Our Ref: BR/125/19/PL

**Town & Country Planning Act 1990 (as amended)
Town and Country Planning (Development Management Procedure) (England) Order 2015
Application for Full Planning Permission**

Development Side and extension to existing mixed use building to provide additional retail space at ground level, 1 No. first floor studio flat & 2 No. studio flats to new roof extension.

Location 1-2 The Parade Argyle Road Bognor Regis

project title	1-2 Argyle Road, Bognor Regis
drawing title	Existing Ground & First Floor Plan

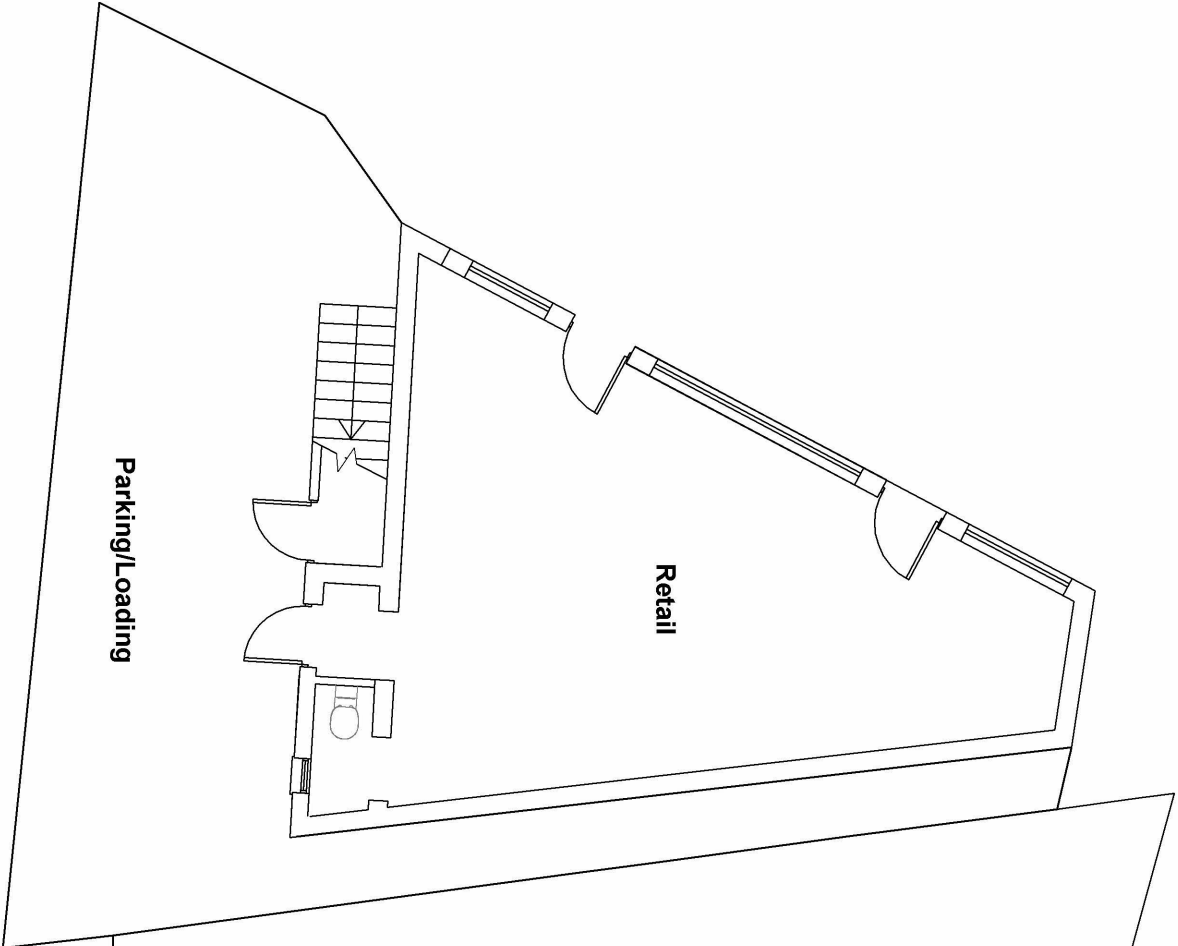
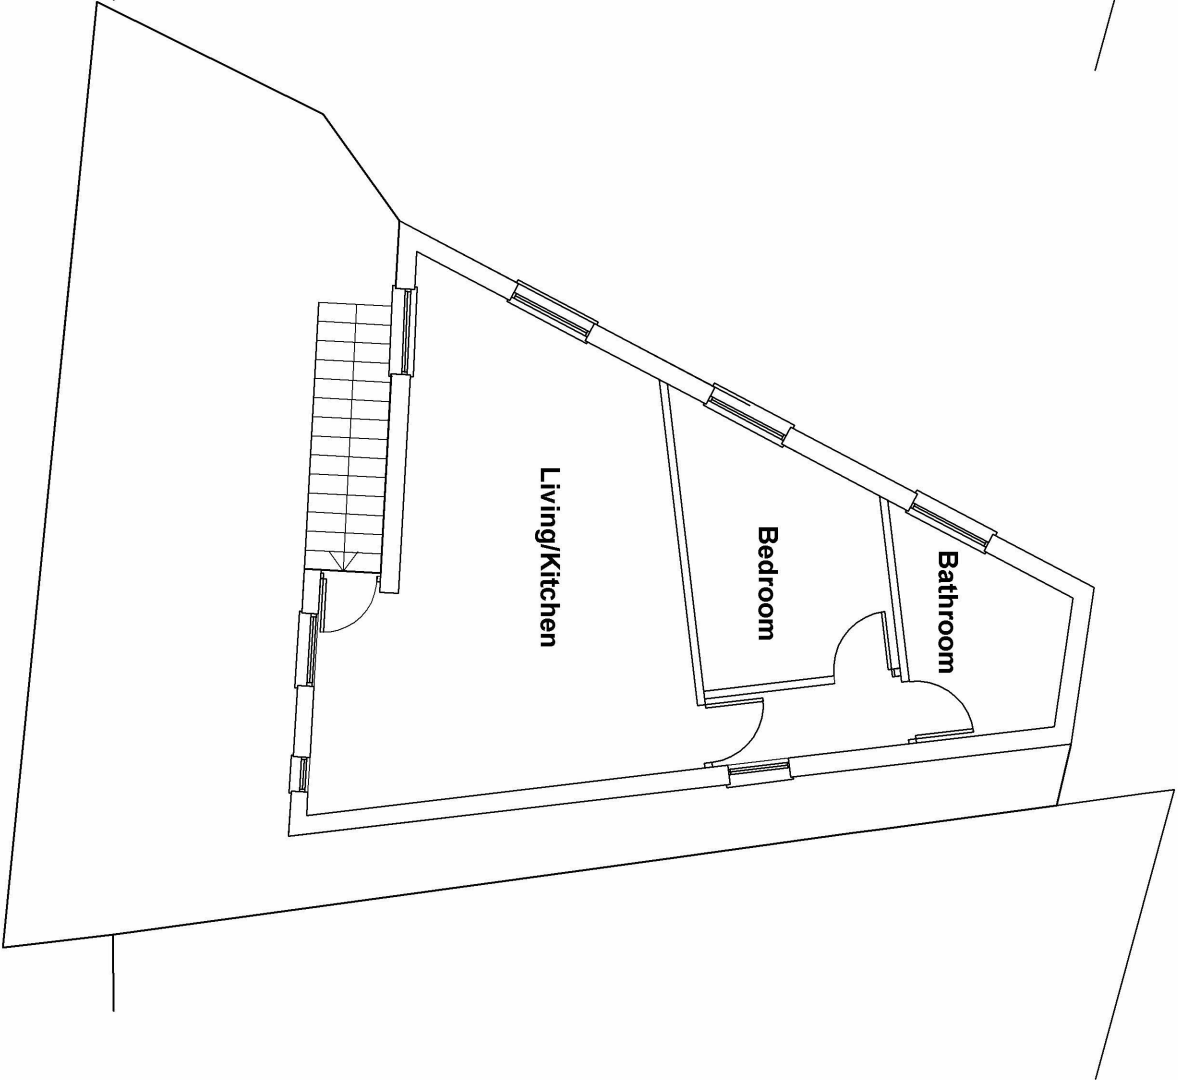
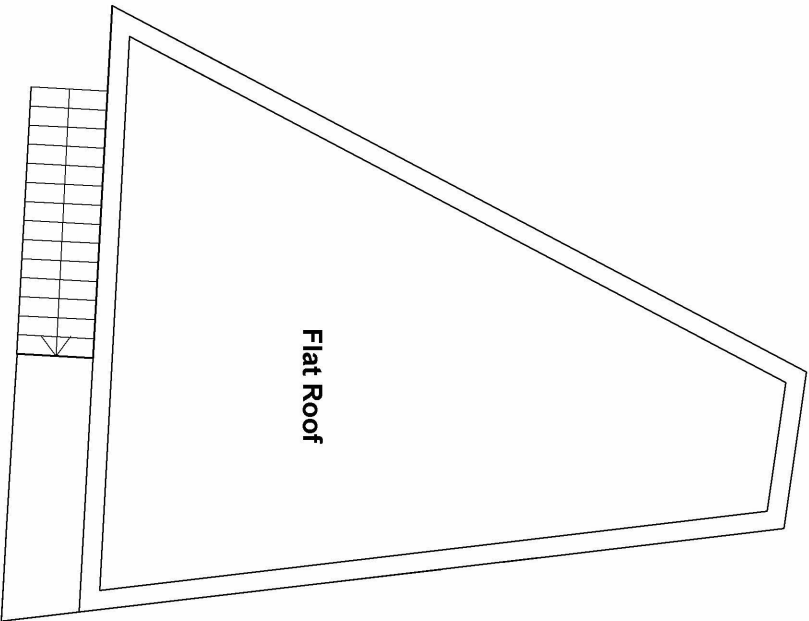
Please provide existing floor plans and elevations.

| project title | 1-2 Argyle Road, Bognor Regis   |
|---------------|---------------------------------|
| drawing title | Proposed 1st and 2nd Floor Plan |

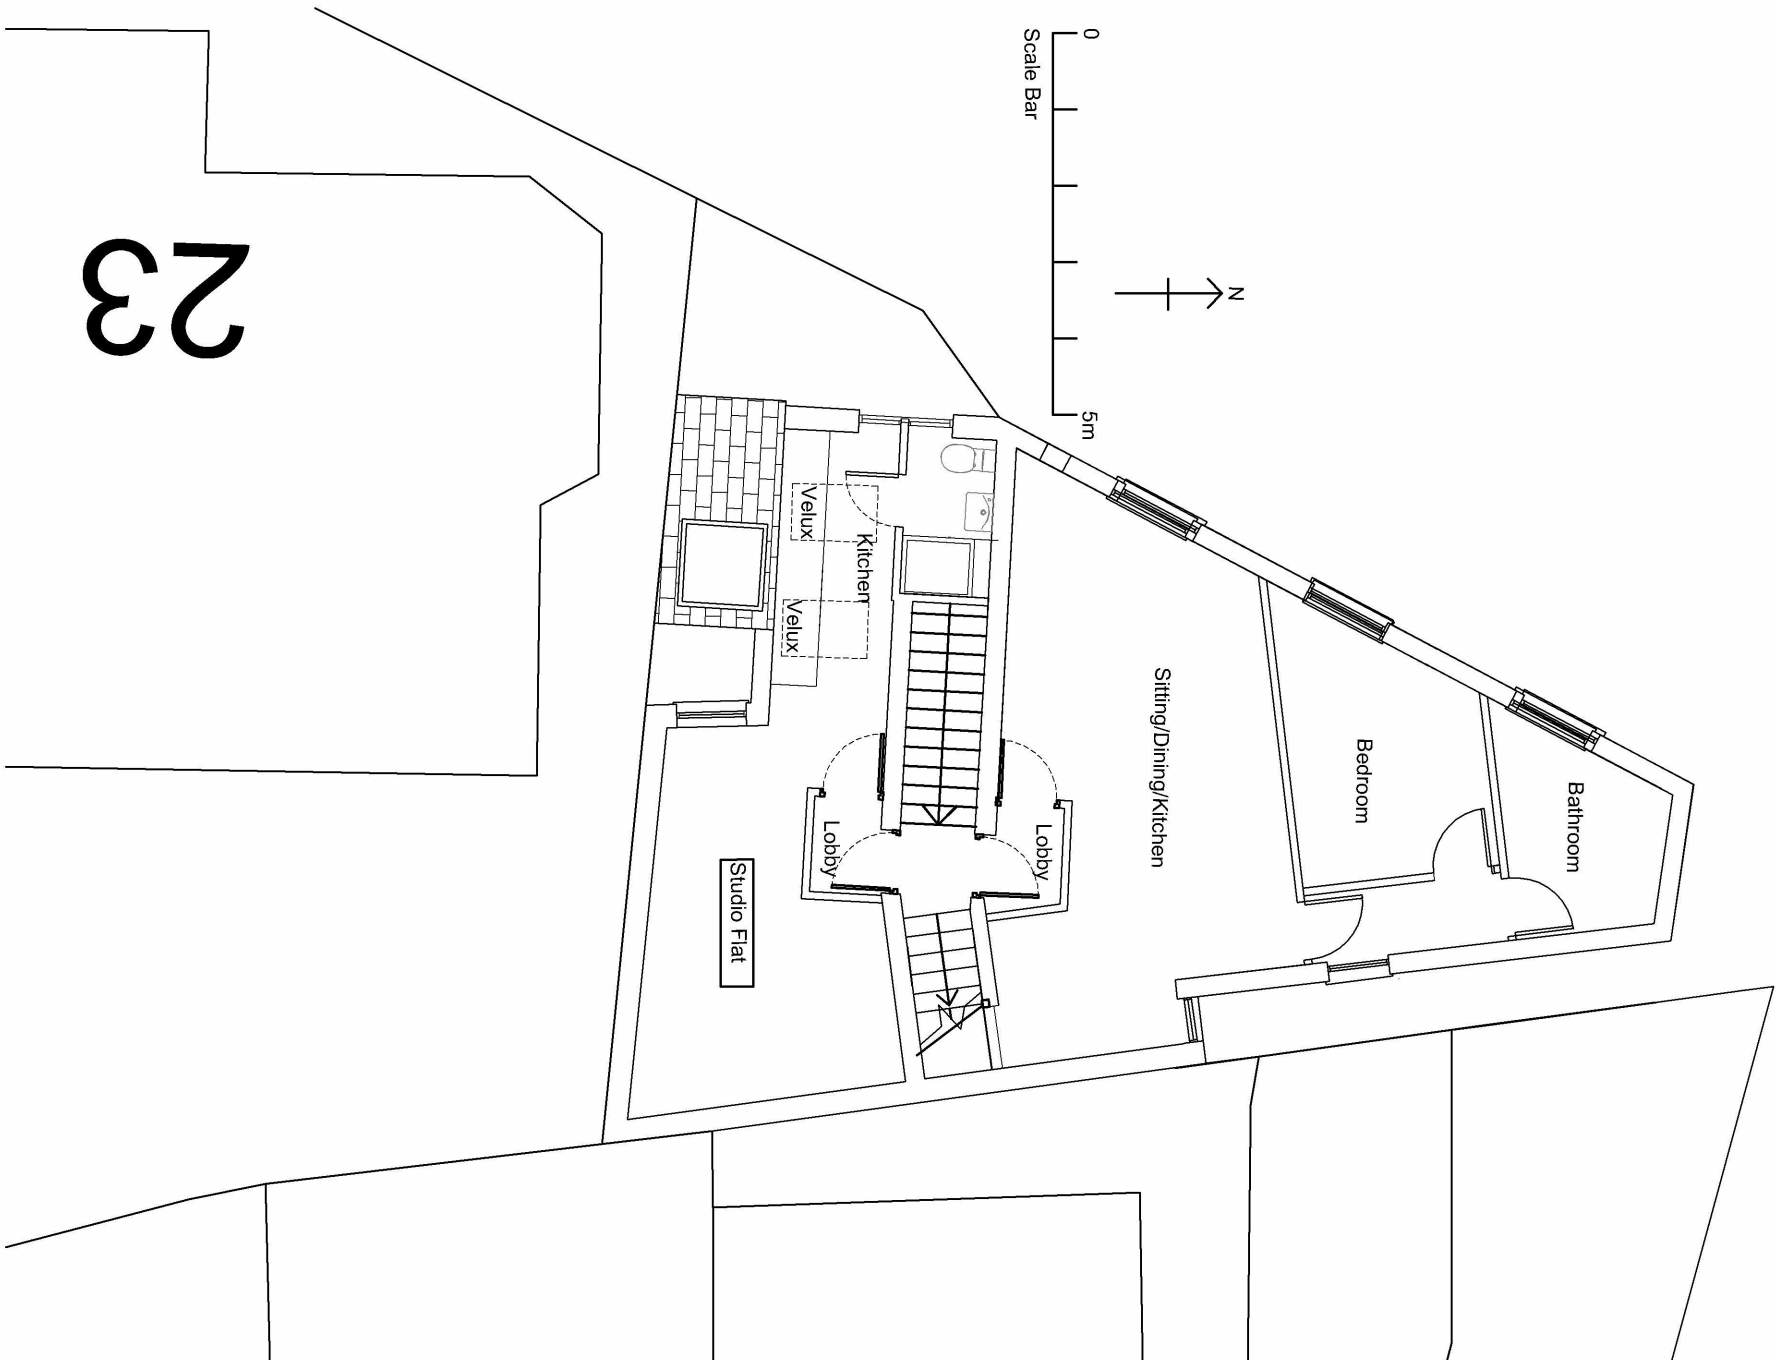
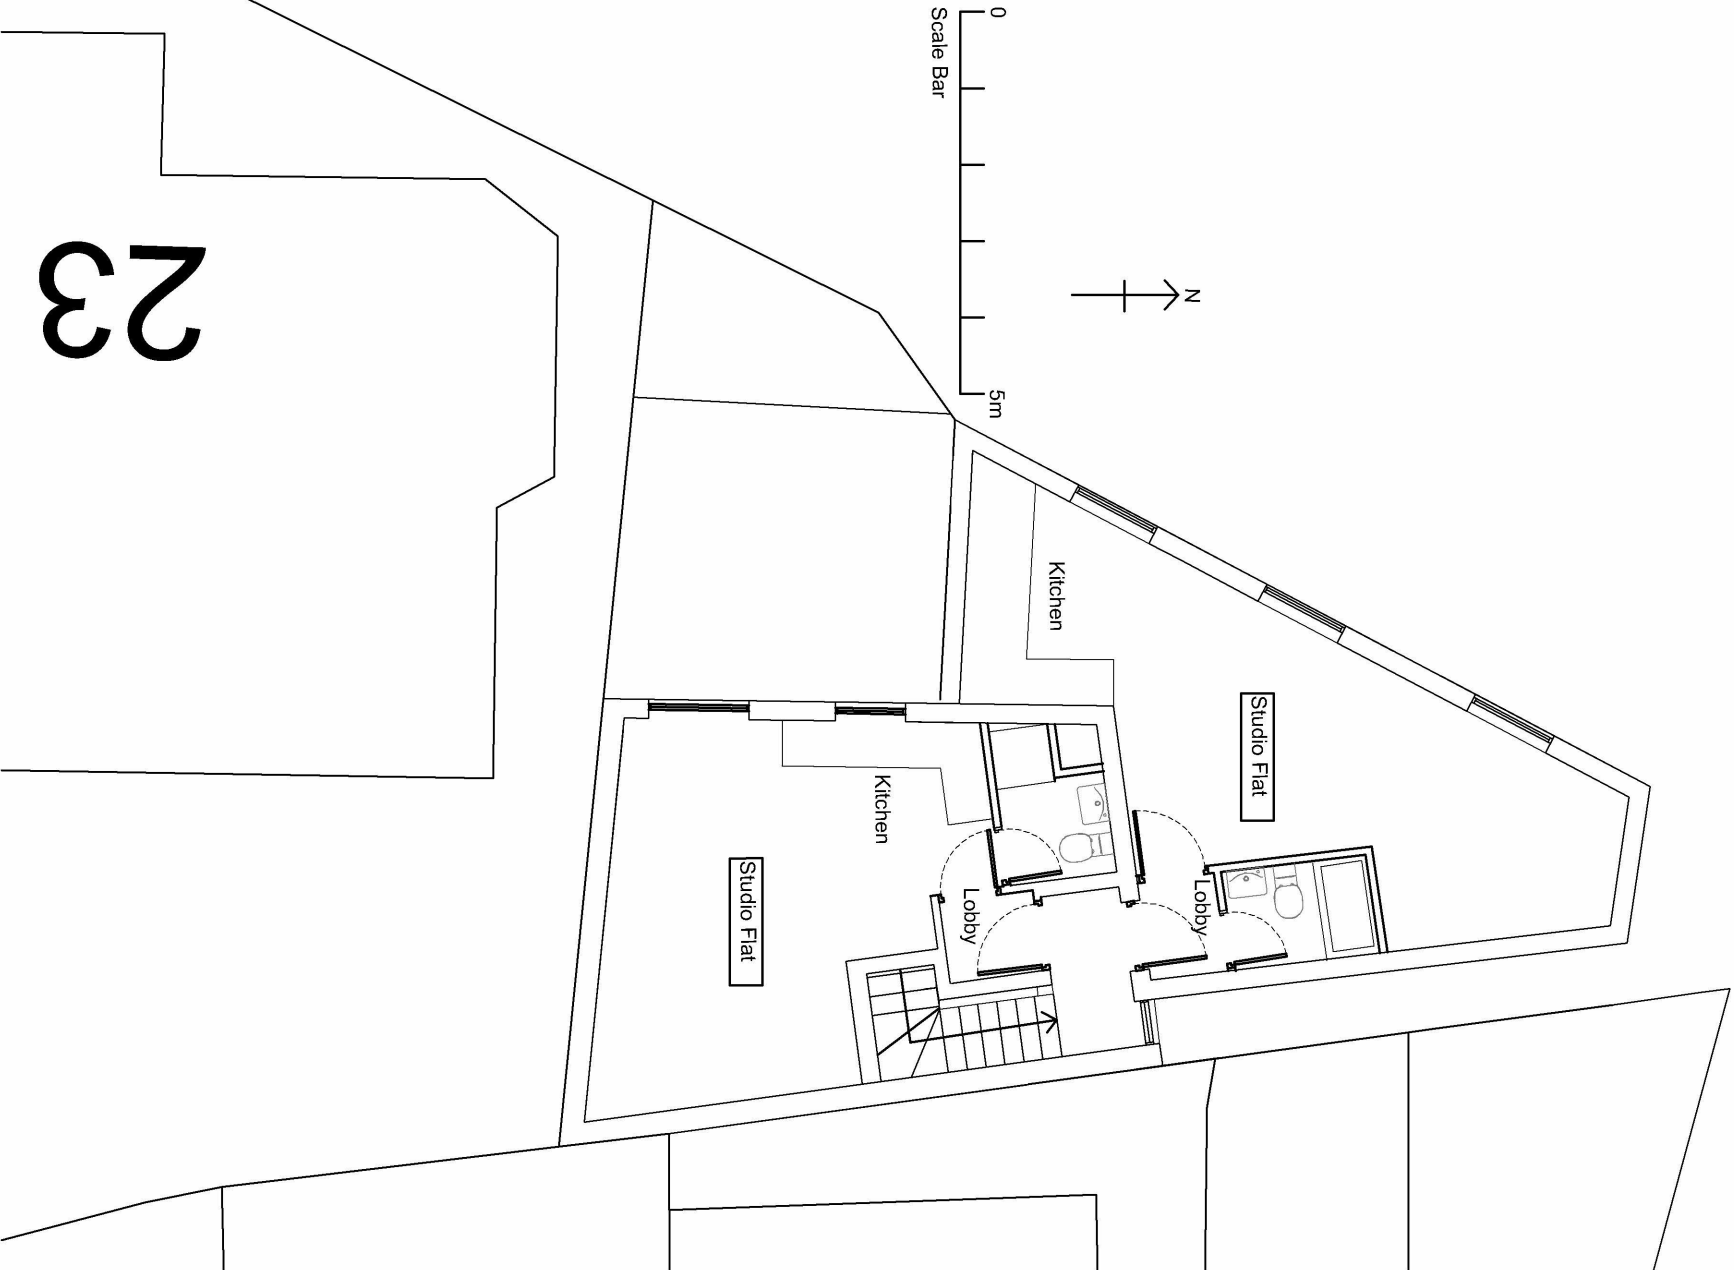
The proposed west elevation and second floor plan do not accord. Please amend accordingly.

The proposed east elevation and first floor plan do not accord. Please amend accordingly.
